October 3, 2023

Site: 4719 86th Ave SE SP
Mercer Island, WA 98040
TPN: 7598100420
Area: 28,644 sq ft. = .66 acres

Re: Results of air-vac-ing the soil at the CRZ of trees 233, 234, 249, 253, 254

TREE PLAN

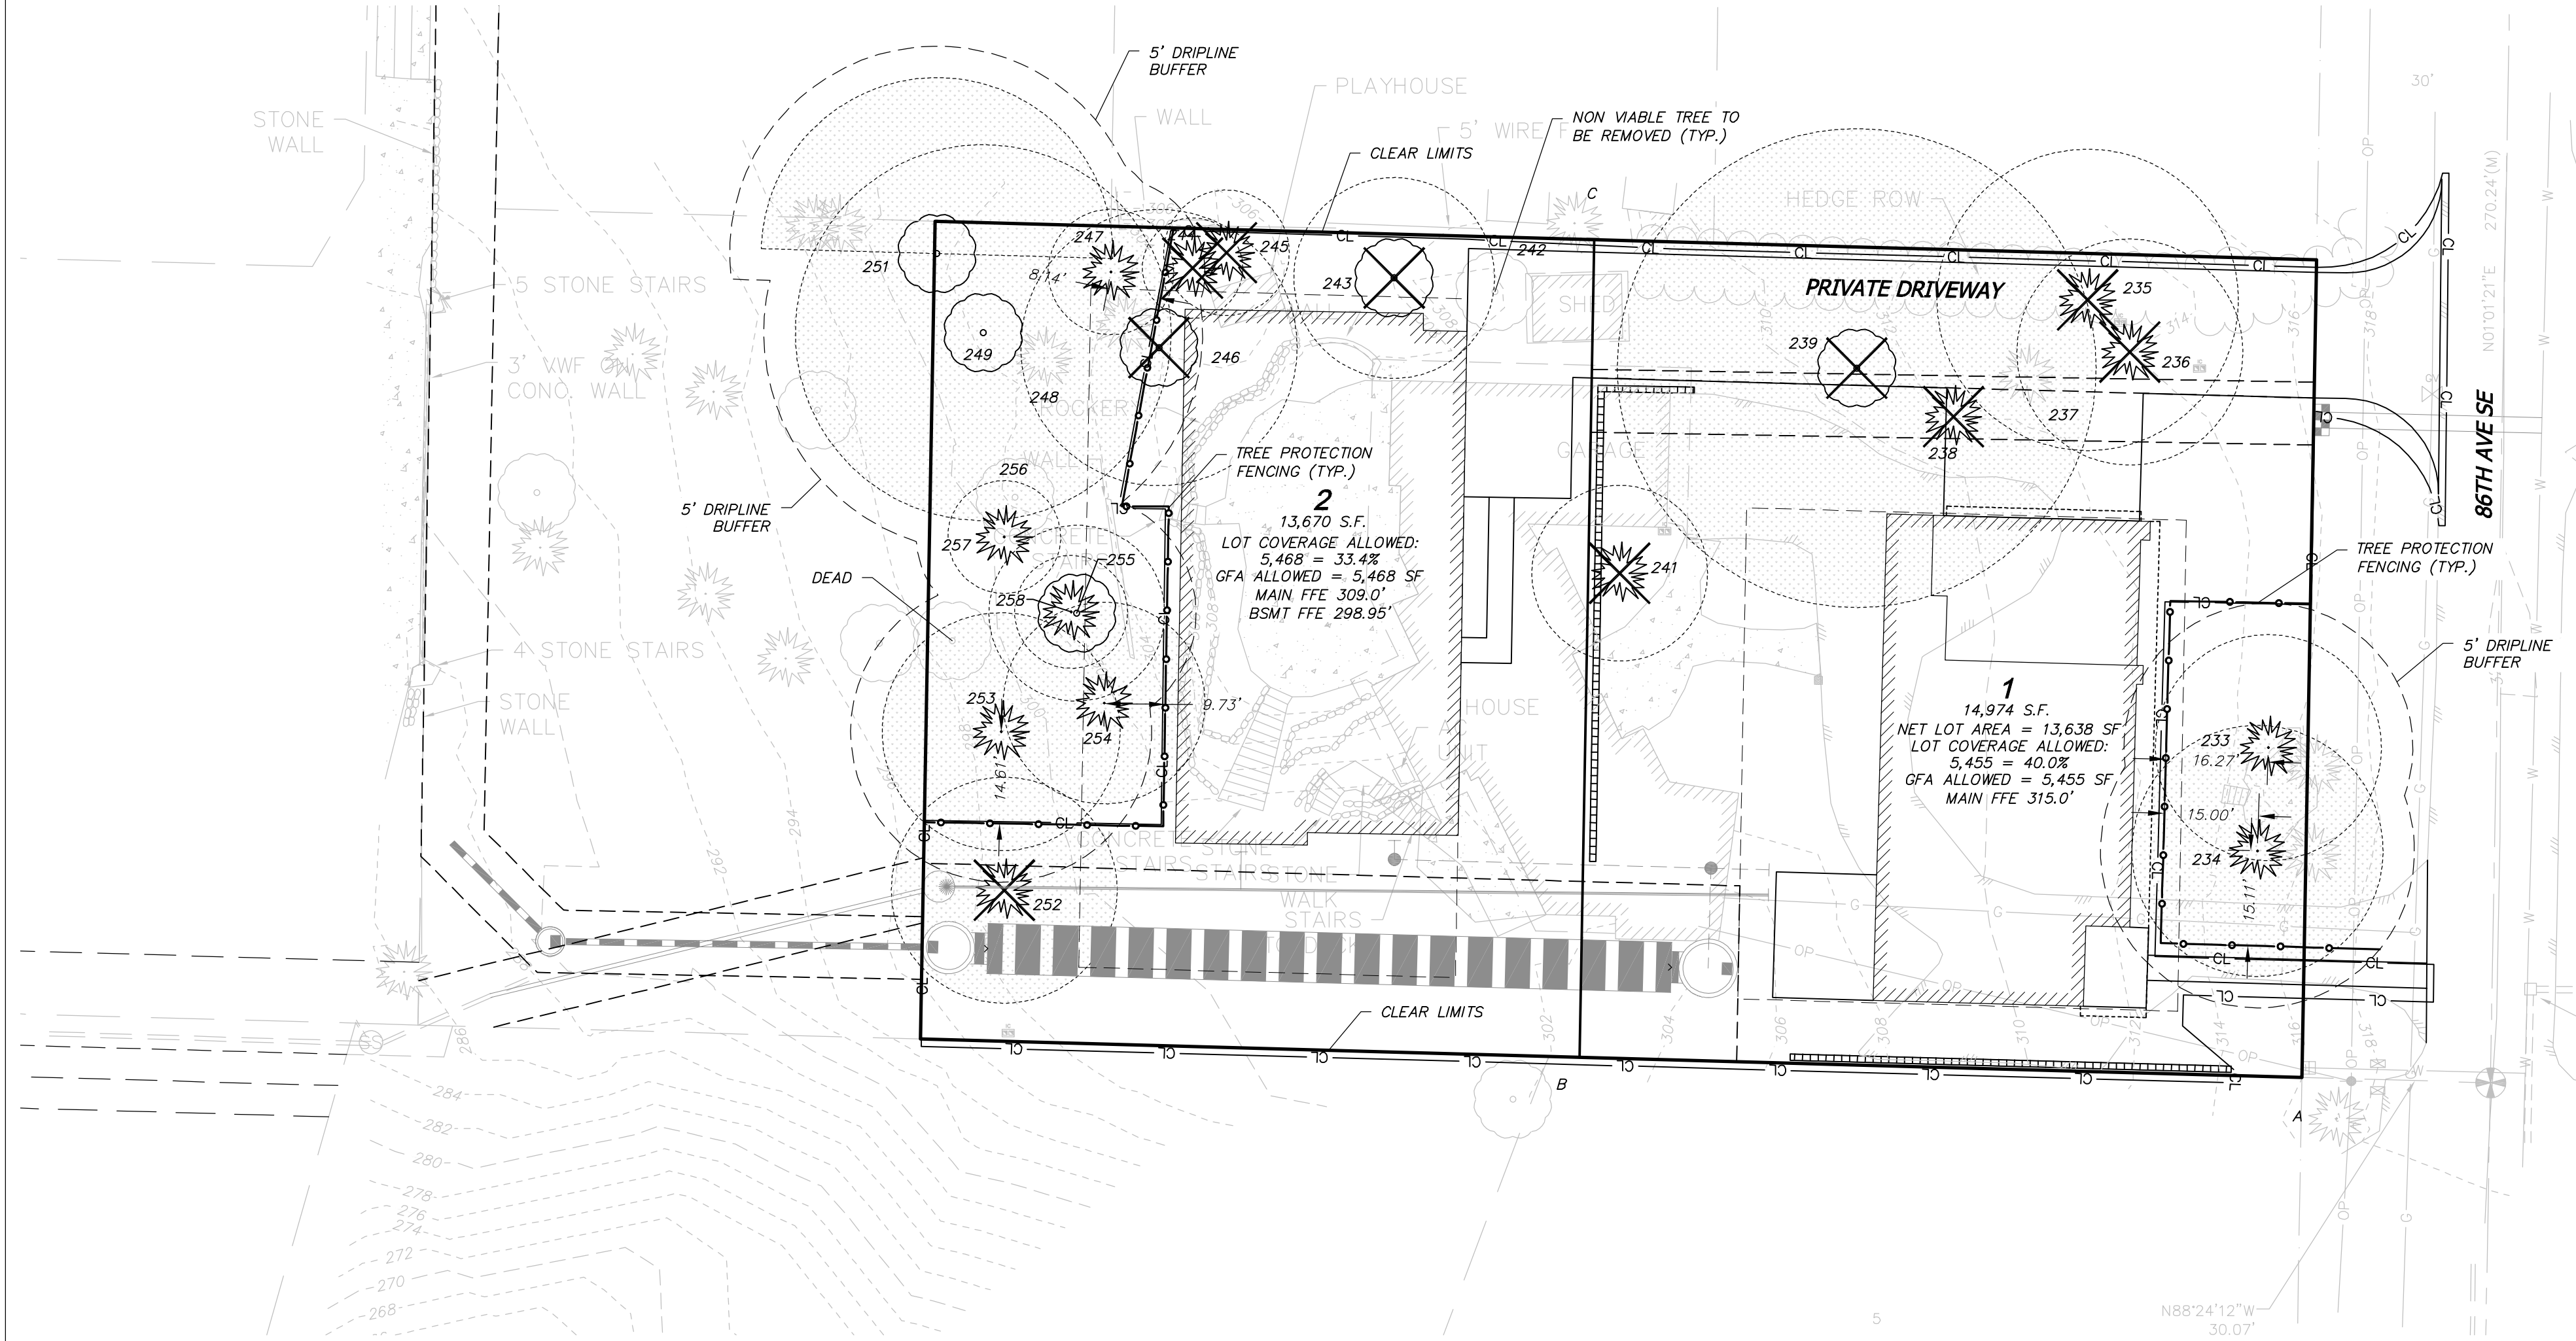
8. Please move the building pad and over excavation outside of the critical root zones of trees 233, 234, 249, and 253. Air excavation root analysis will need to be provided prior to construction to demonstrate that these trees will not be damaged by the proposed work. The analysis will need to call out the specifics of the project design. Alternatively, these trees could be proposed to be removed if the minimum required number of regulated trees will be retained.

This tree is located among a group of similar trees. At the point of air=evacuation, three (3) roots were uncovered. One (1) was a four (4") diameter root that appears to be from tree #246 – a tree proposed to be removed, and two (2") roots that appear to originate from this tree. Cutting of these roots should not destabilize nor significantly negatively impact the tree.

The air-evacuation of the soil at the point of proposed encroachment of these five (5) trees did not expose any large diameter roots, or any group of roots that would, in my opinion, warrant tree removal.
